**Consultation Response from KC,
Trees**

2025/93572 Land South of, Barnsley Road, Upper Cumberworth, Huddersfield, HD8 8NN

Outline application with all matters reserved, bar vehicle access into the site, for erection of up to 123 dwellings with associated works including open space, landscaping, drainage infrastructure.

Date Responded: 19/02/2026

Dwg No. E25/8281/001
 Date: DEC 25
 Scale: 1/500 @A1

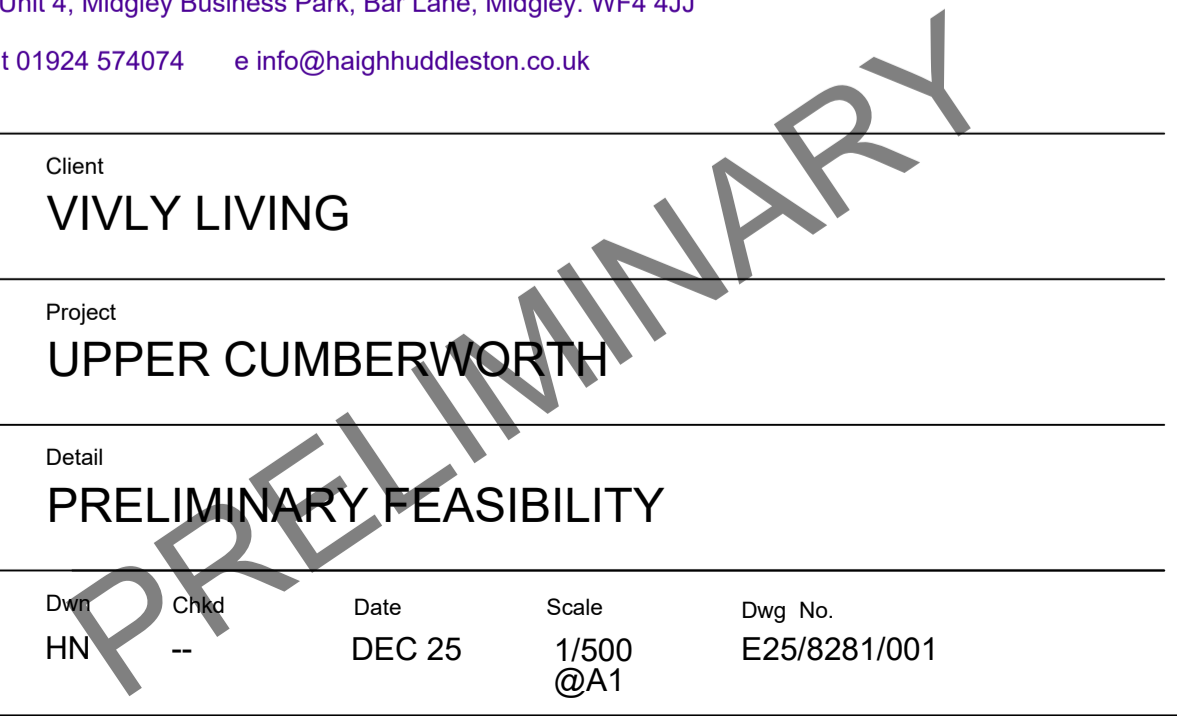
3. There is a drainage feature proposed through the Ancient Woodland Buffer Zone (AWBZ), which would discharge the surface water sewer to Park Dike, within Stephen Wood. Changes to the water table or drainage can directly affect ancient woodlands. This may result in damage or deterioration of an irreplaceable habitat. An alternate solution should be considered to avoid discharging surface water directly to the dike within the ancient woodland. For example, A SUDS feature would allow for surface water to be temporarily stored and slowly drain from the site, whilst creating valuable areas of seasonal wetland for increased biodiversity.

Layout For Illustration Purpose Only.

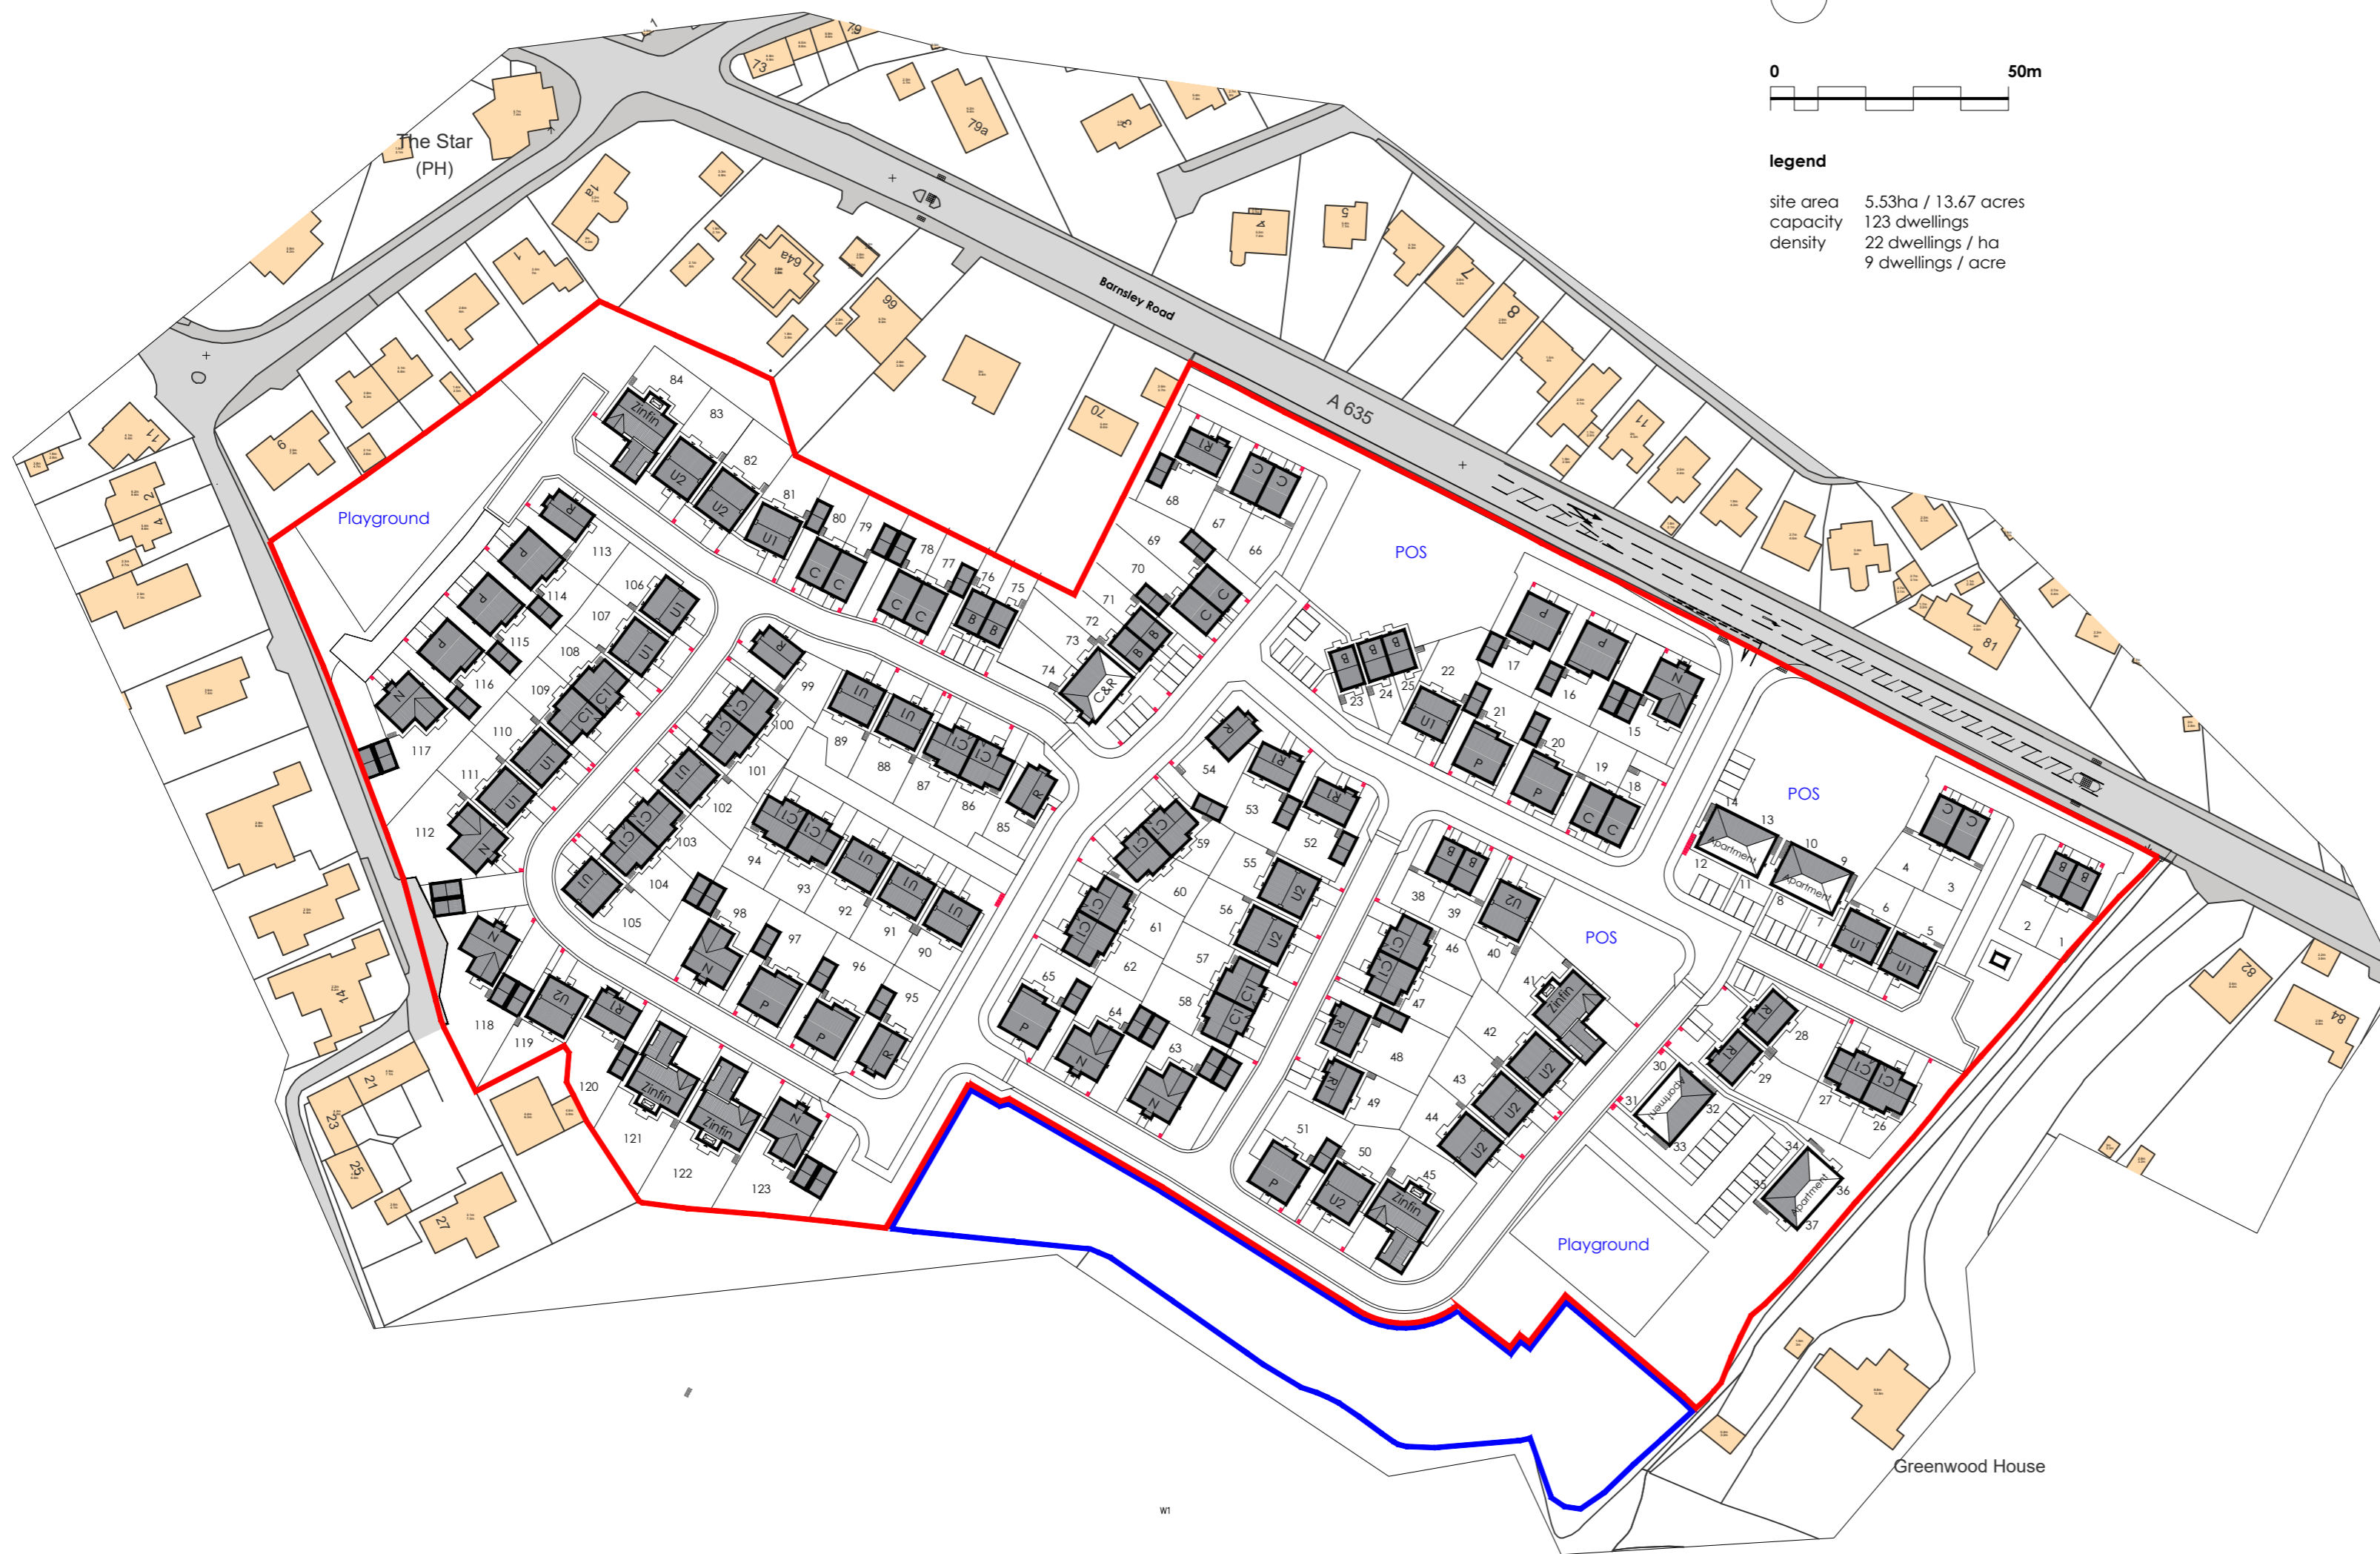
1. TPO 20/25/t1. The outline scheme does not propose to retain this protected tree, which is a prominent feature, considered by local people as an important landmark. All valuable trees should be retained in line with LP33, the NPPF and BS5837:2012.

2. TPO 20/25/t2. This tree is an impressive specimen and has been misrepresented within the tree survey; being recorded as three separate trees, instead of one triple stemmed tree. Recording the tree in this way skews the data to show a significantly smaller RPA than is likely to be present. There are incursions associated with the proposed pumping station into the RPA, which are likely to be significant and therefore unacceptable.

5. No tree-lined streets are shown on the outline proposals. NPPF Ch.12 p.136 states that all new streets should be tree-lined to help to mitigate and adapt to climate change.

6. The layout design does not avoid direct tree impacts, or consider the ultimate, mature size of trees adjacent to proposed structures, as required by BS5837:2012 to avoid future conflicts.

7. Off-site trees are impacted by the proposed layout; again, as part of good design, setting plots far enough back from retained trees can avoid present and future conflicts.

8. The government guidance minimum distance of 15m between the edge of the ancient woodland and the proposed development is not observed within the plans. The Government Guidance *Ancient woodland, ancient trees and veteran trees: advice for making planning decisions* (January 2022) states that:
